Charlotte Department of Transportation

Memorandum

Subject: Rezoning Petition 08-130: Located on the northwest corner of North Davidson Street and Charles Avenue (*revised 8/19/08*)

DUMPSTER TRUCK SITE ACCESS DIAGRAM  
SCALE: N.T.S.

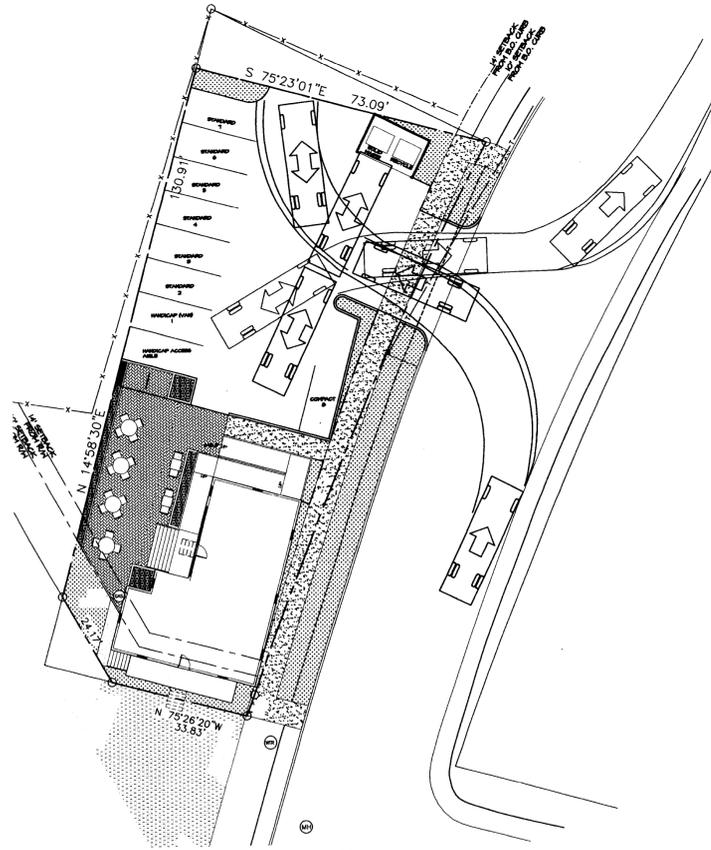
2. The maneuvering path for waste collection vehicles accessing the dumpster needs to be shown on the site plan. Maneuvering is not permitted in the setback or right-of-way. As shown, it appears that maneuvering is required in both of these areas.

PROPOSED SITE PLAN  
SCALE: 1/16" = 1'-0"

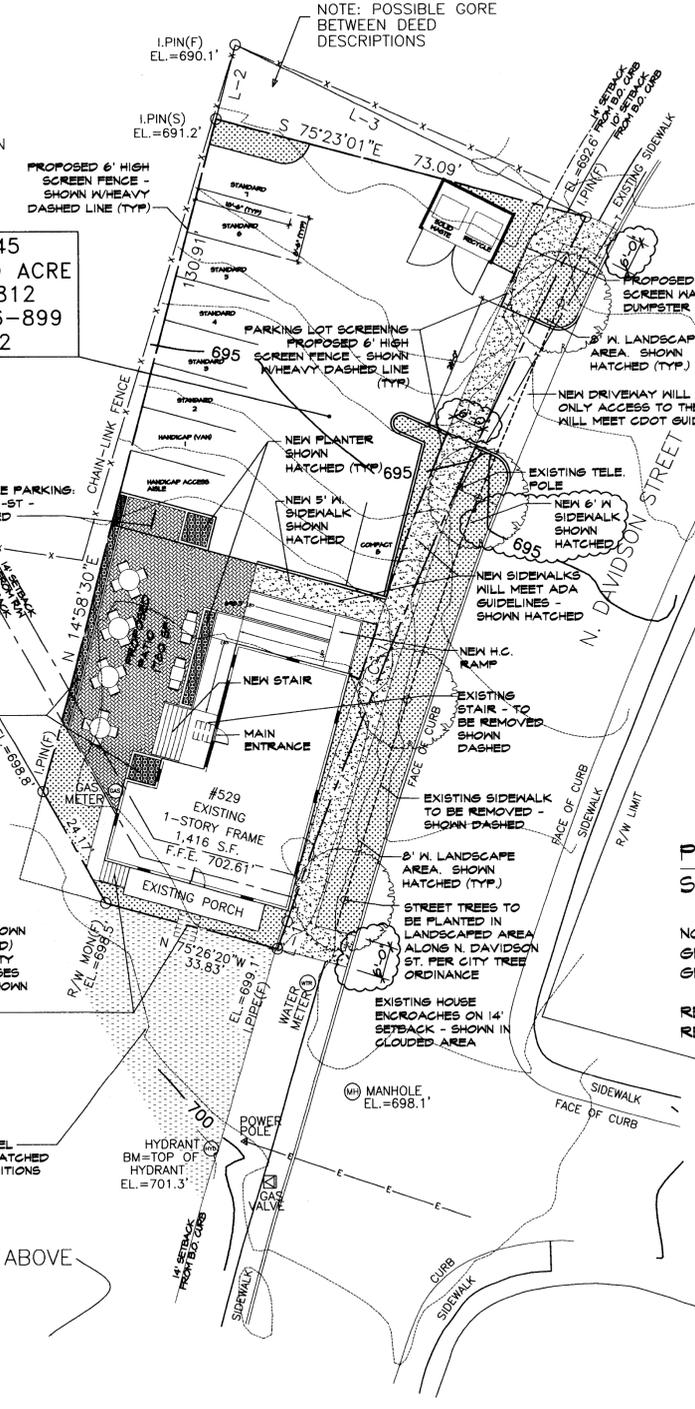
1. Two of the three optional requests proposed on the site plan will not be supported by CDOT. The first request is not supported because the street trees need to be located between the curb and sidewalk as shown on the plan. The second request is not supported because the site is constrained and at a critical point in a curve where sight distance is an issue, so paved parking provides the optimal maneuvering surface.
